Review Response

Project Name: Septimus Community Association

Response To: SHL22-019 & SEP22-014 Request for Information, 6460 E Mercer Way (Septimus Community Association)

**SHEET**  
**A5.0**

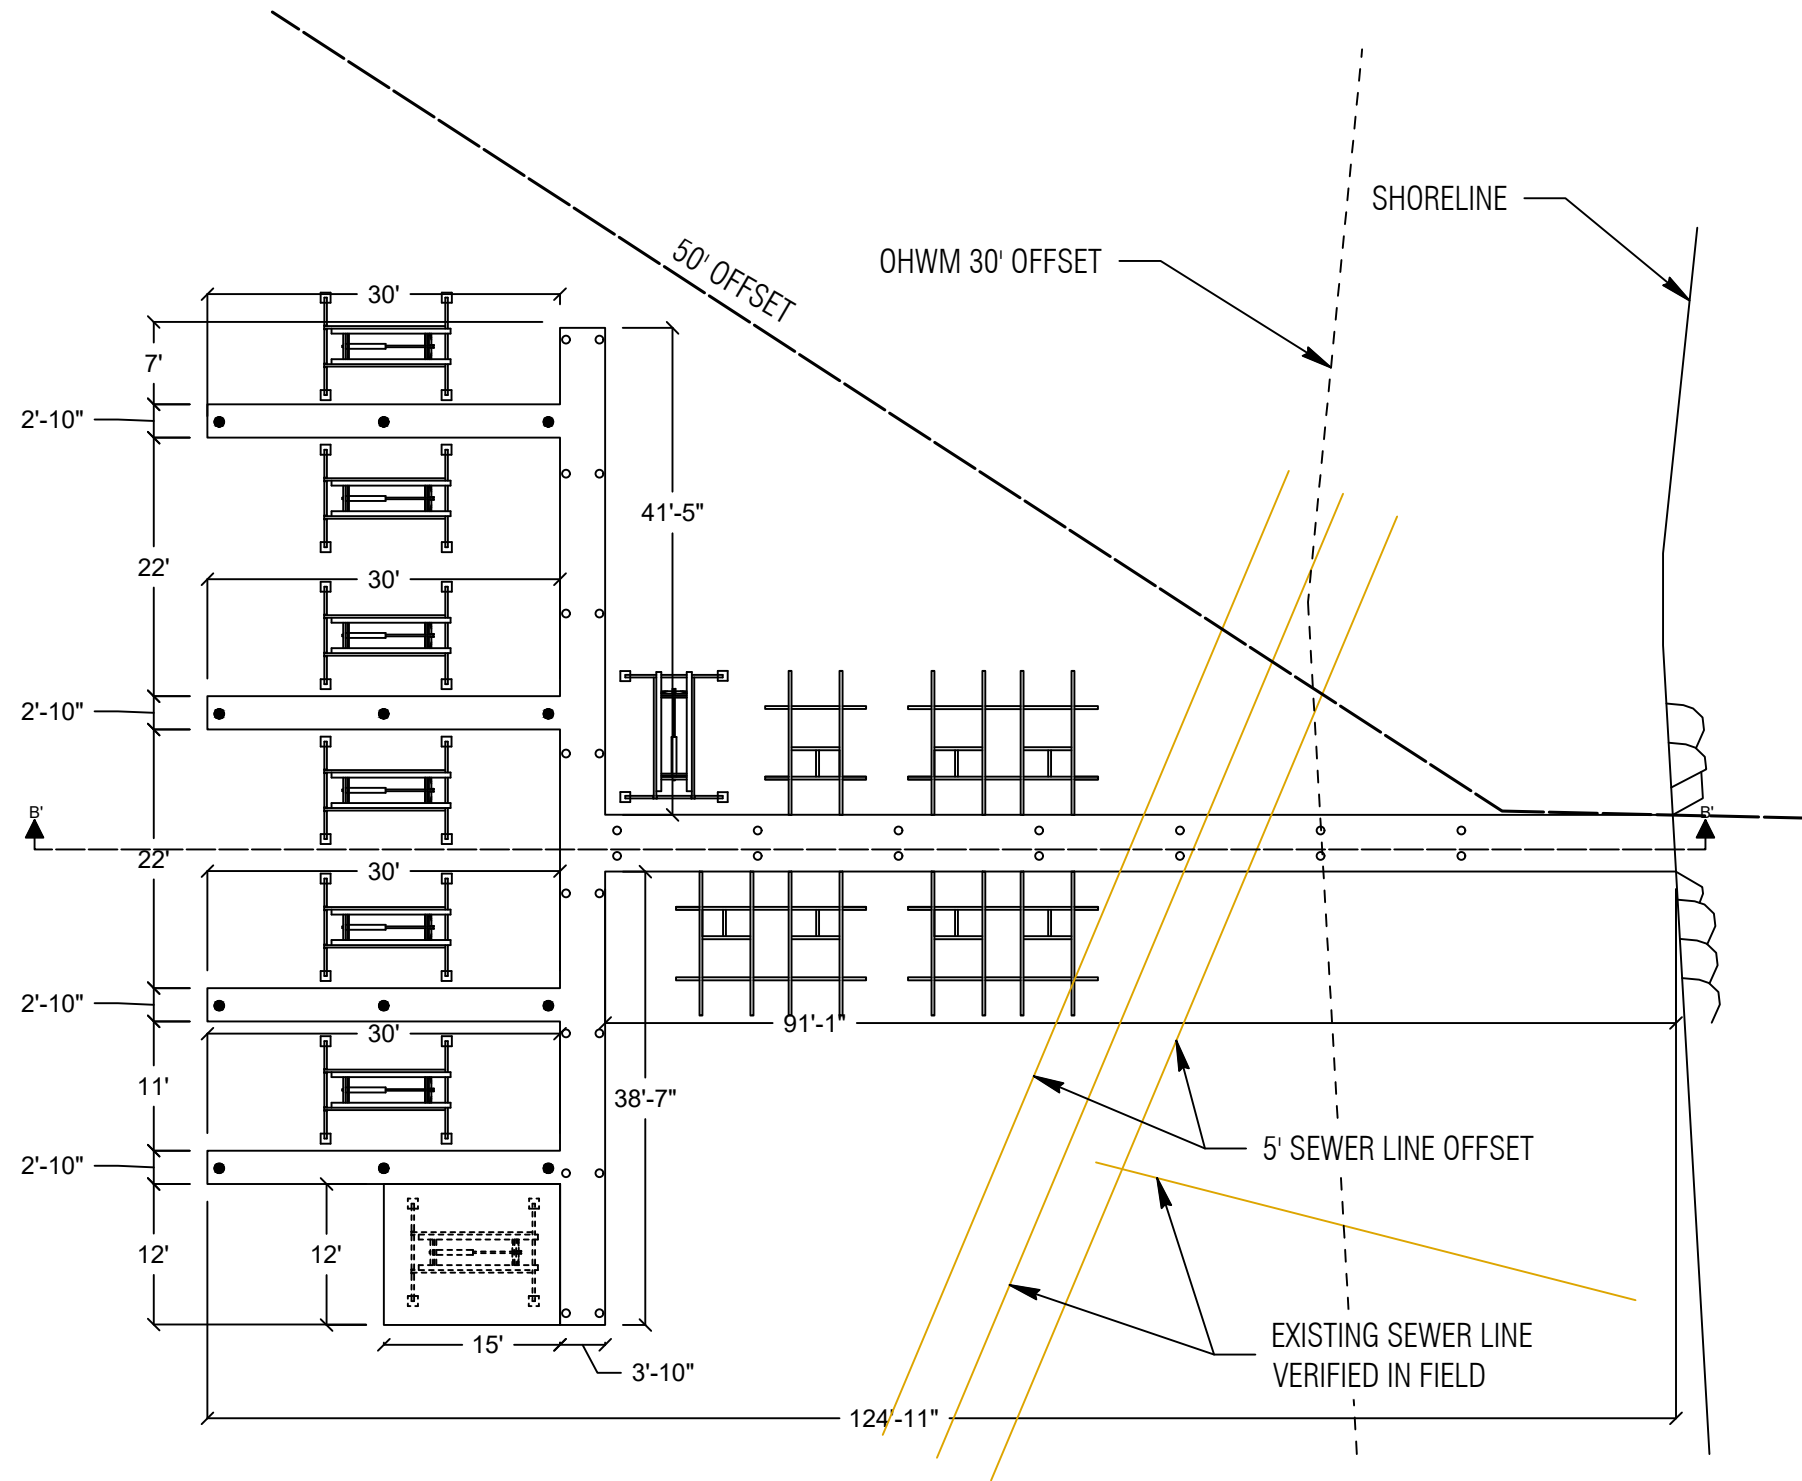
1. The proposed dock width within 30 feet of the OHWM is shown as 4'10" wide. The maximum width allowed is 4' within 30 feet of OHWM. Please narrow the dock width in that section, or provide documentation that demonstrates that the proposal meets the criteria shown in MICC 19.13.050 Table D Section E.

See attached documentation of state disability of one of the Septimus residents, per WAC 308-96B-010. The proposed walkway width provides adequate ADA accessibility.

**SHEET**  
**A7.0**

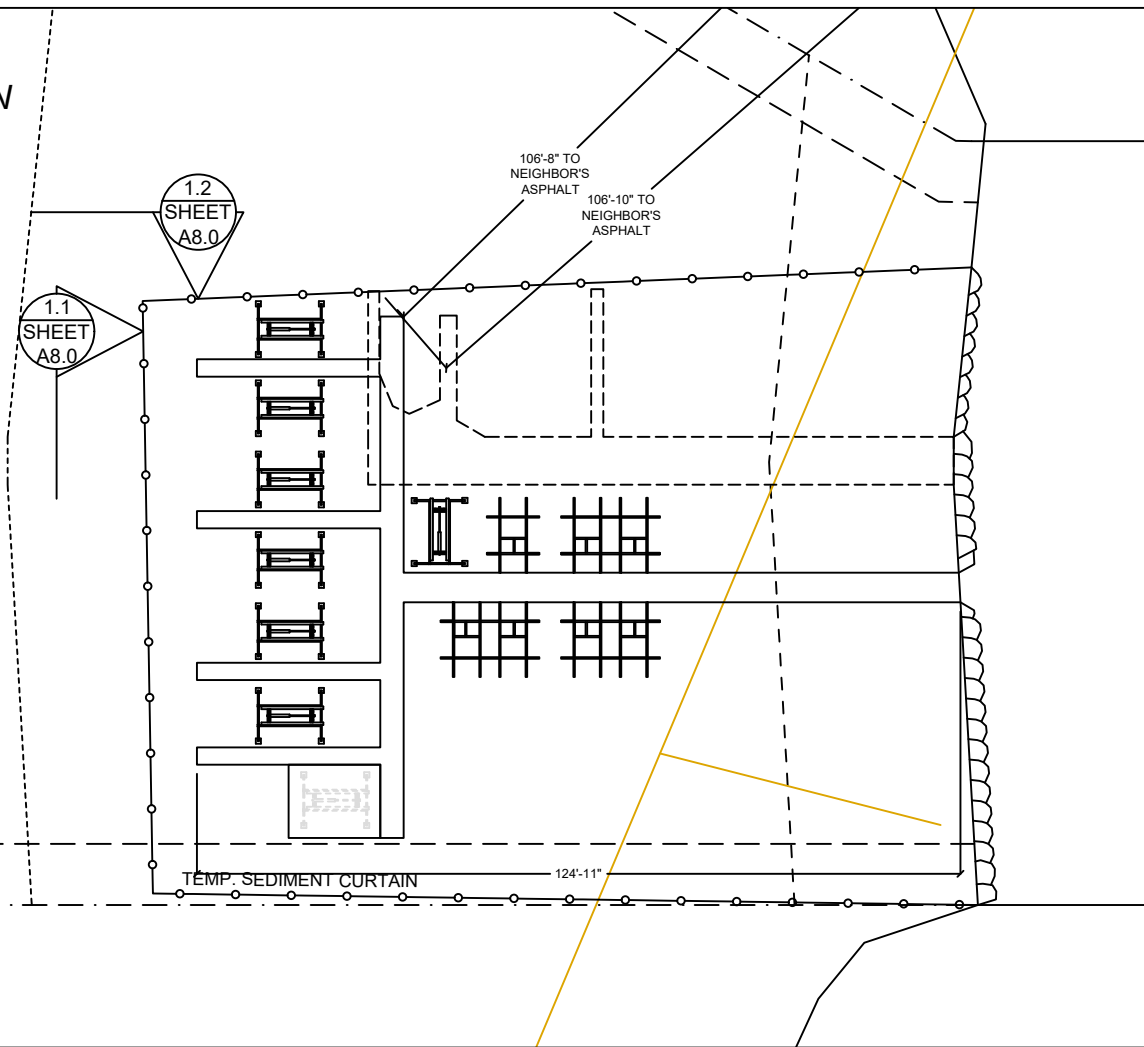
2. Sheet A7.0 of the plan set shows the water depths for the proposed project. Please show where the water depth is 11.85', and that the proposed dock is within that allowed water depth.

See page A7 of updated plan set. The proposed dock ends just before hitting the maximum water depth of 11.85'.

# HARDSCAPE CALCULATION EXISTING/PROPOSED

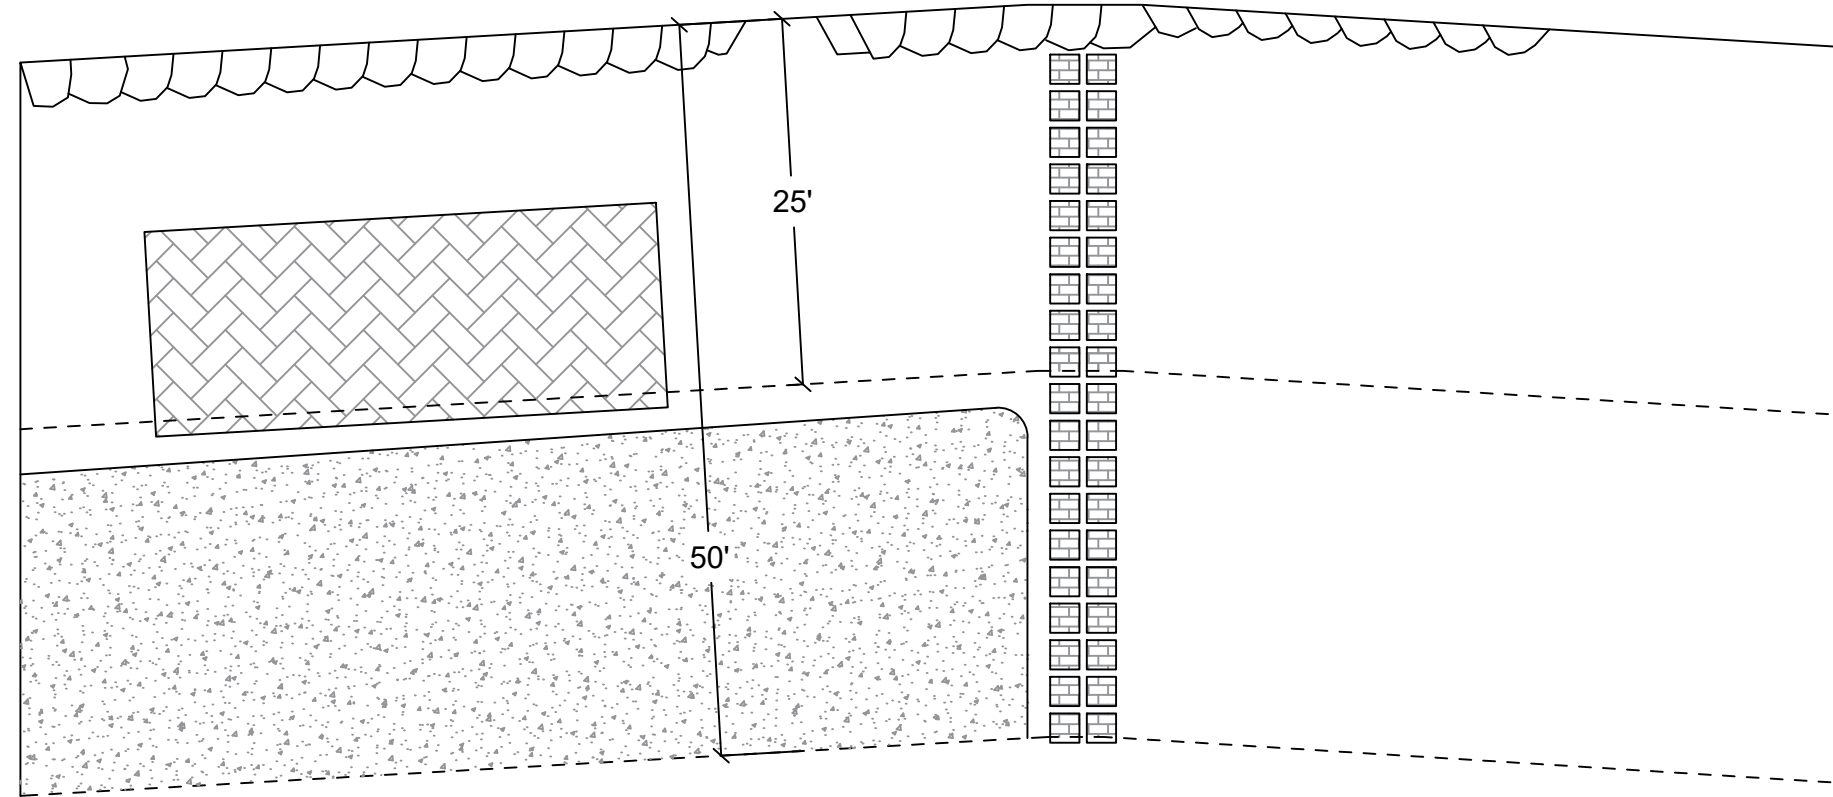
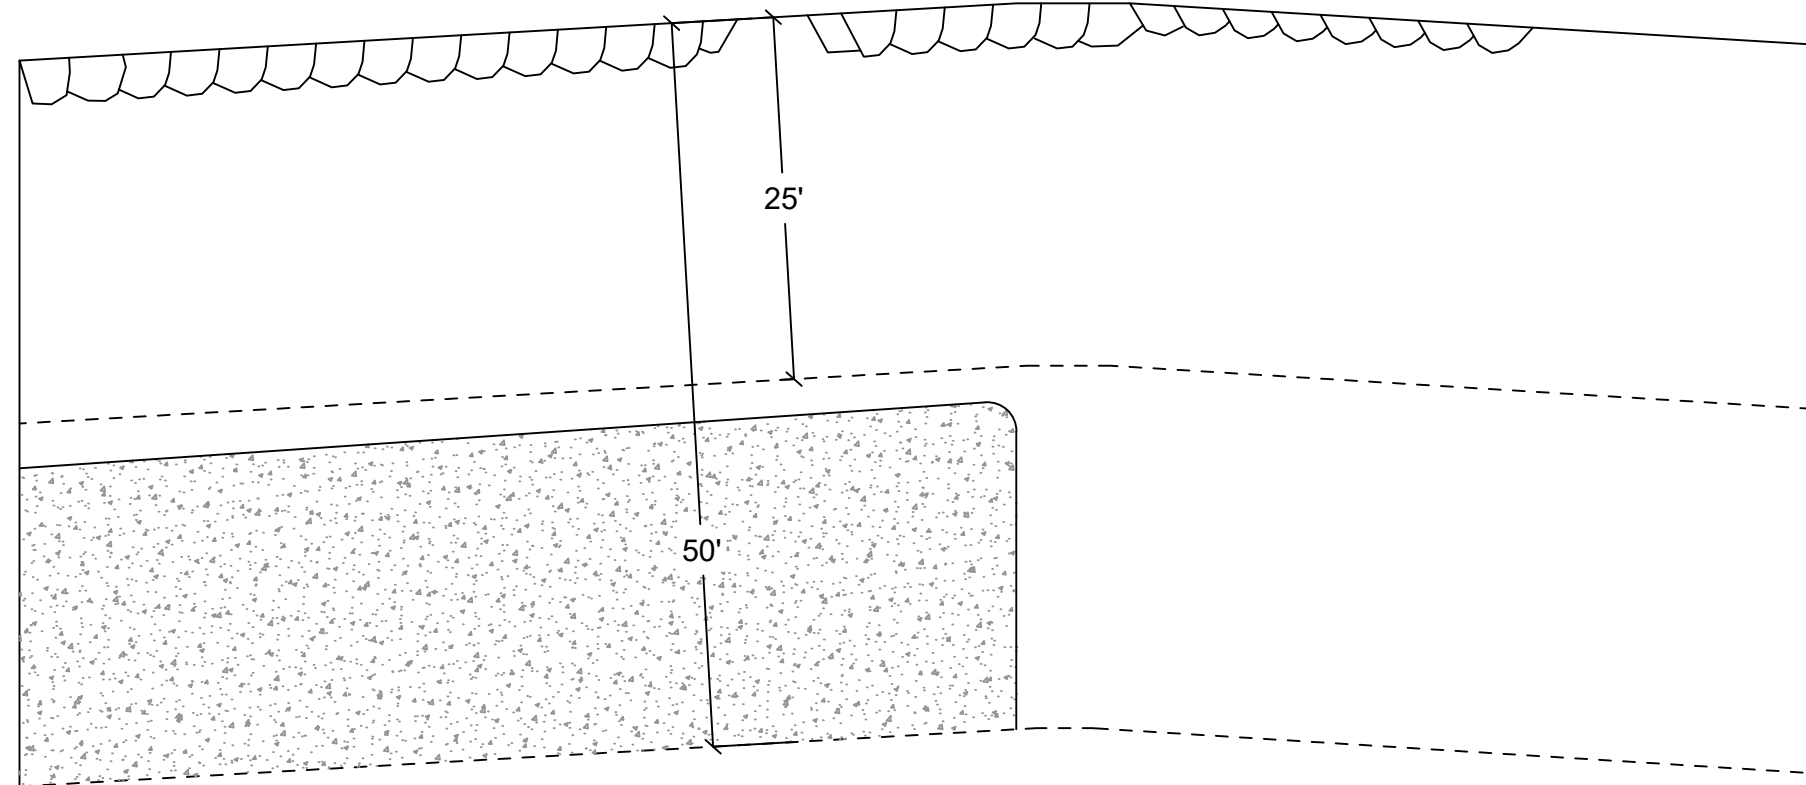
3. There appears to be a recently installed patio in the shoreline area, which is not shown as existing on the plans. Please update the plan set to include all elements that are currently existing on the site within the shoreline area. Also, please provide documentation that the patio was installed with the required permits and that it meets the maximum hardscape requirements for 0-25 feet and 25-50 feet from OHWM.

See page A15 of updated plan set. The homeowners have agreed to remove the unpermitted hardscape in order to bring the 0-25' shoreline setback area into conformance. The existing parking area in the 25-50' setback area exceeds the hardscape allowance, but is considered legally non-conforming due to its age.
